From: Paul Cann
Sent: 11 December 2017 16:26
To: Planning.Responses
Subject: RE: Planning Consultation on: R/267/17/PL

Engineers comments in respect to surface water drainage:

APPLICATION R/267/17/PL

Description of Works: 2 storey block of 6 No Flats comprising of 4 No. 2 bed & 2 No.
1 bed flats.

Issue	Details	By	Date
SCALE	AS SHOWN on A1		
DATE	20/10/17		
DRAWING NUMBER	15072/03

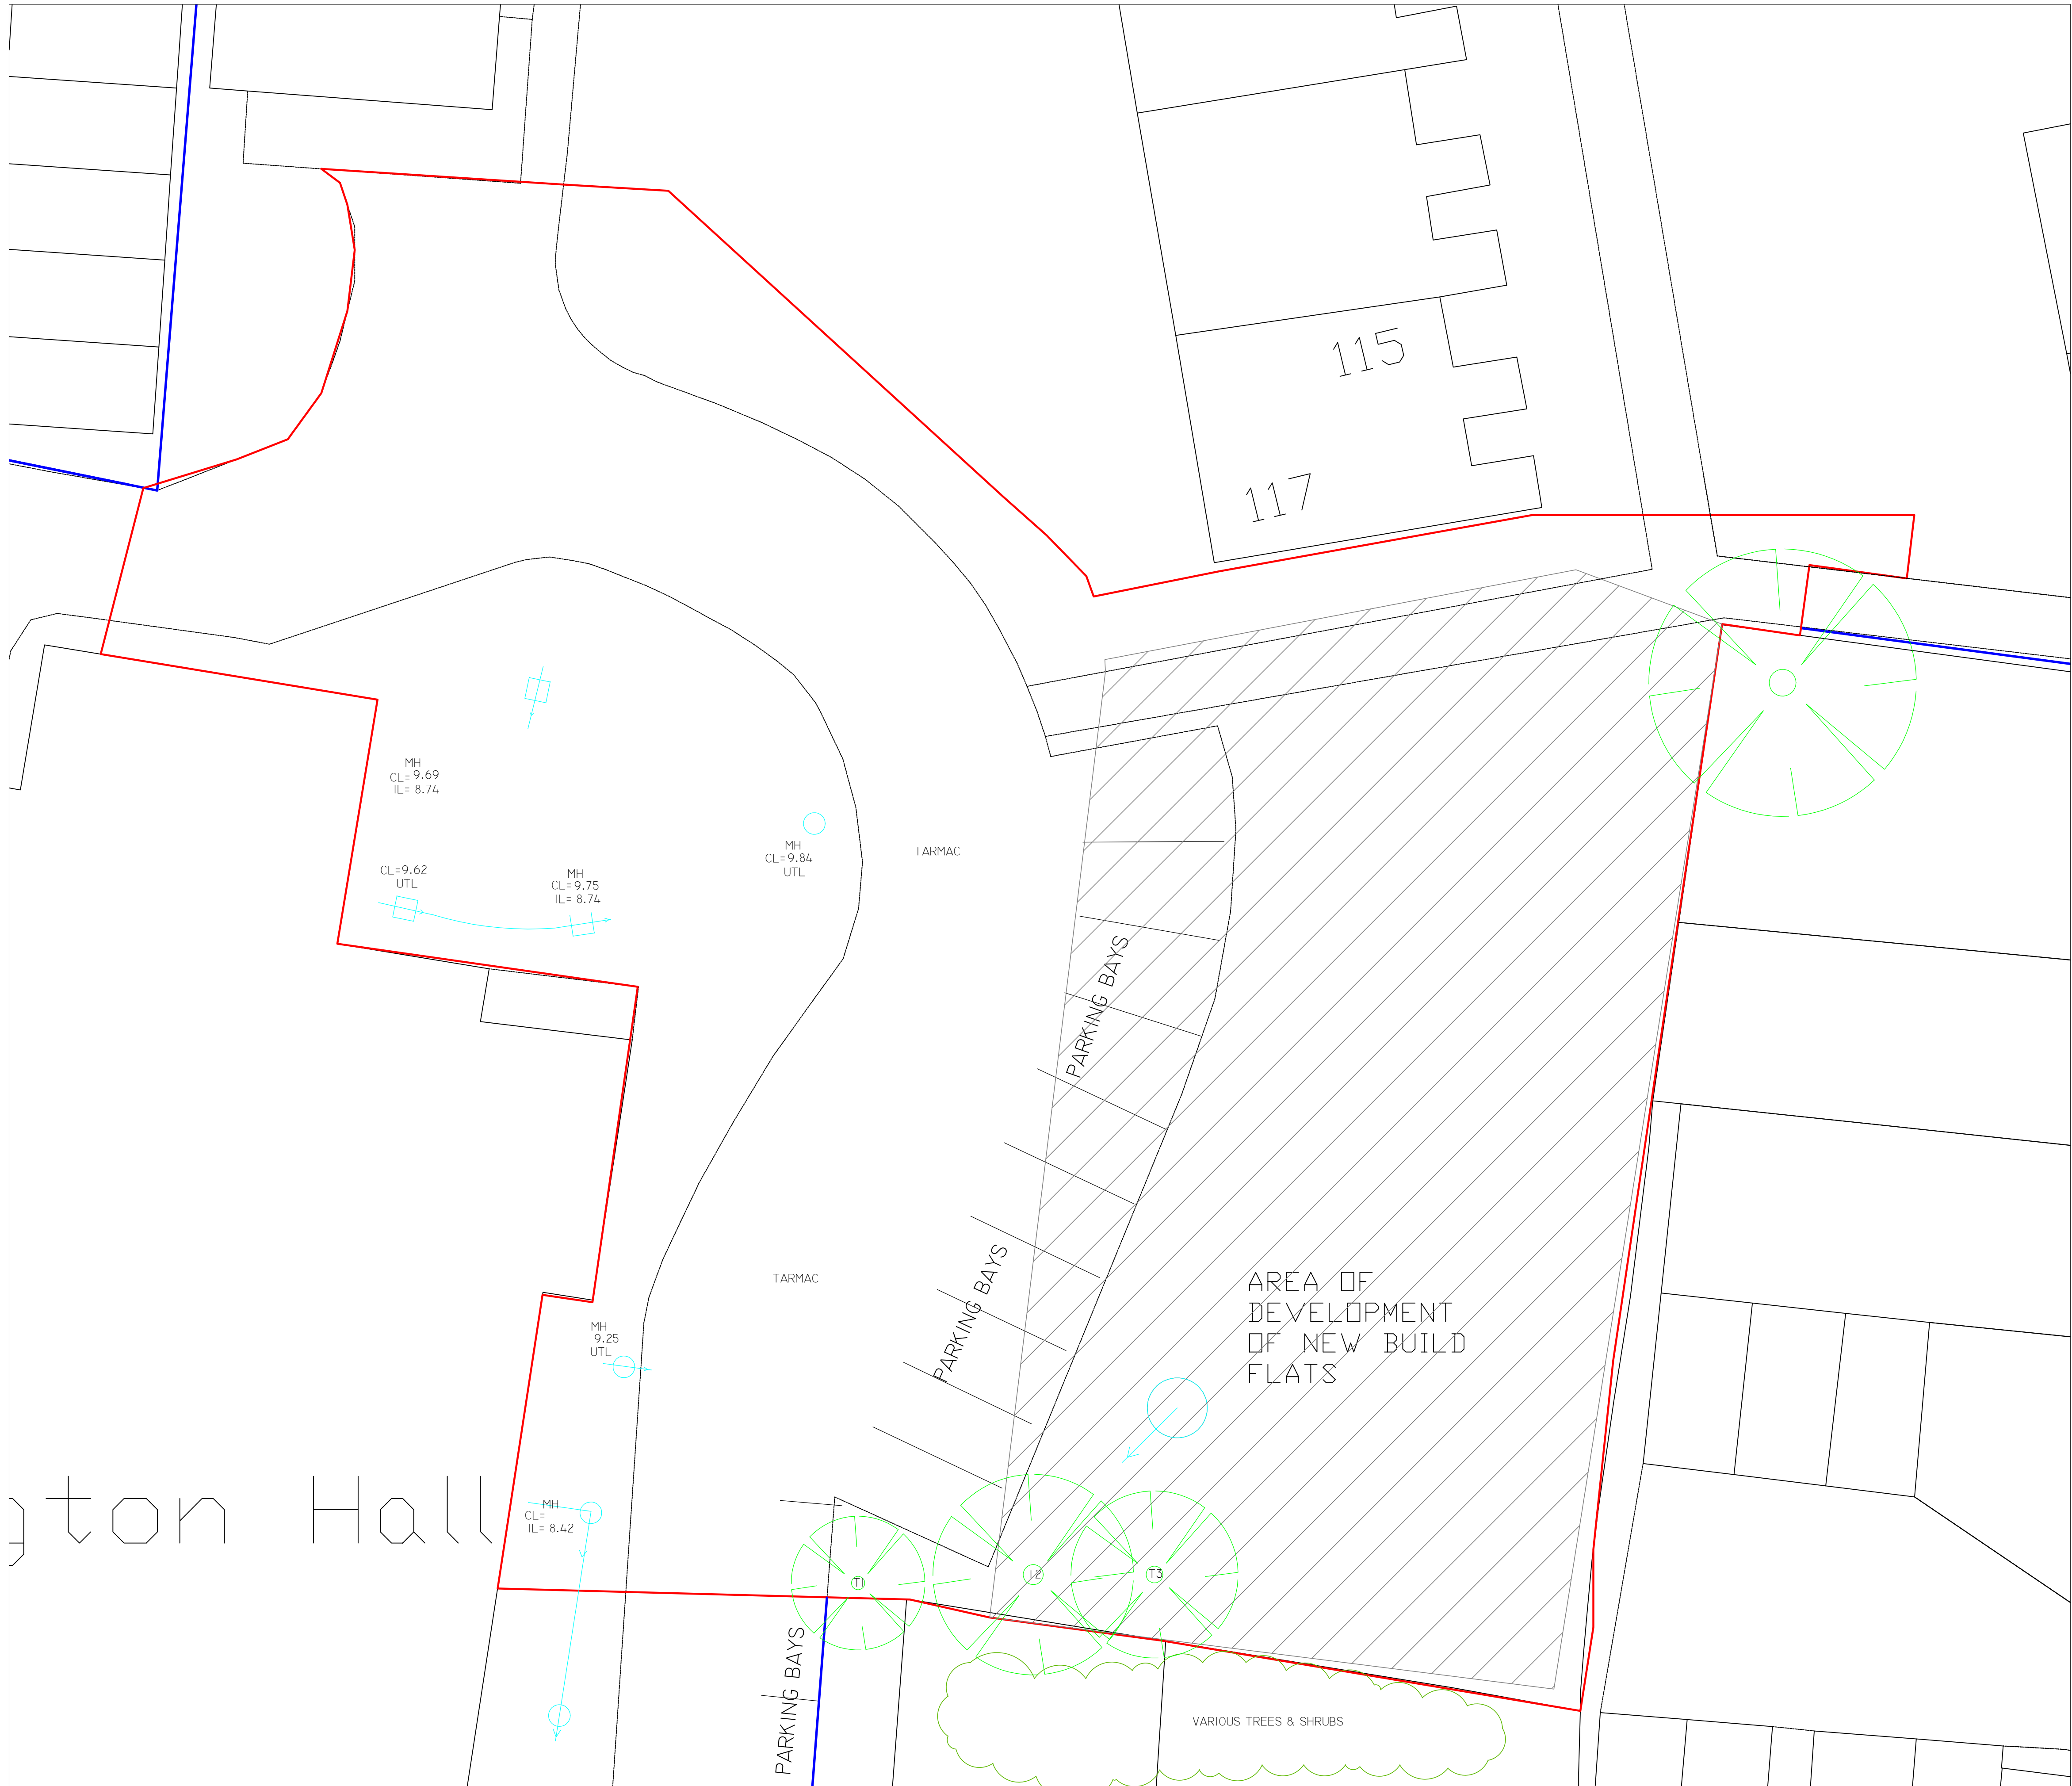
The applicants current drainage layout, appears to show a connection to an assumed existing surface water drainage system (without attenuation) which would not be acceptable. Infiltration must be investigated first, before other options are considered.
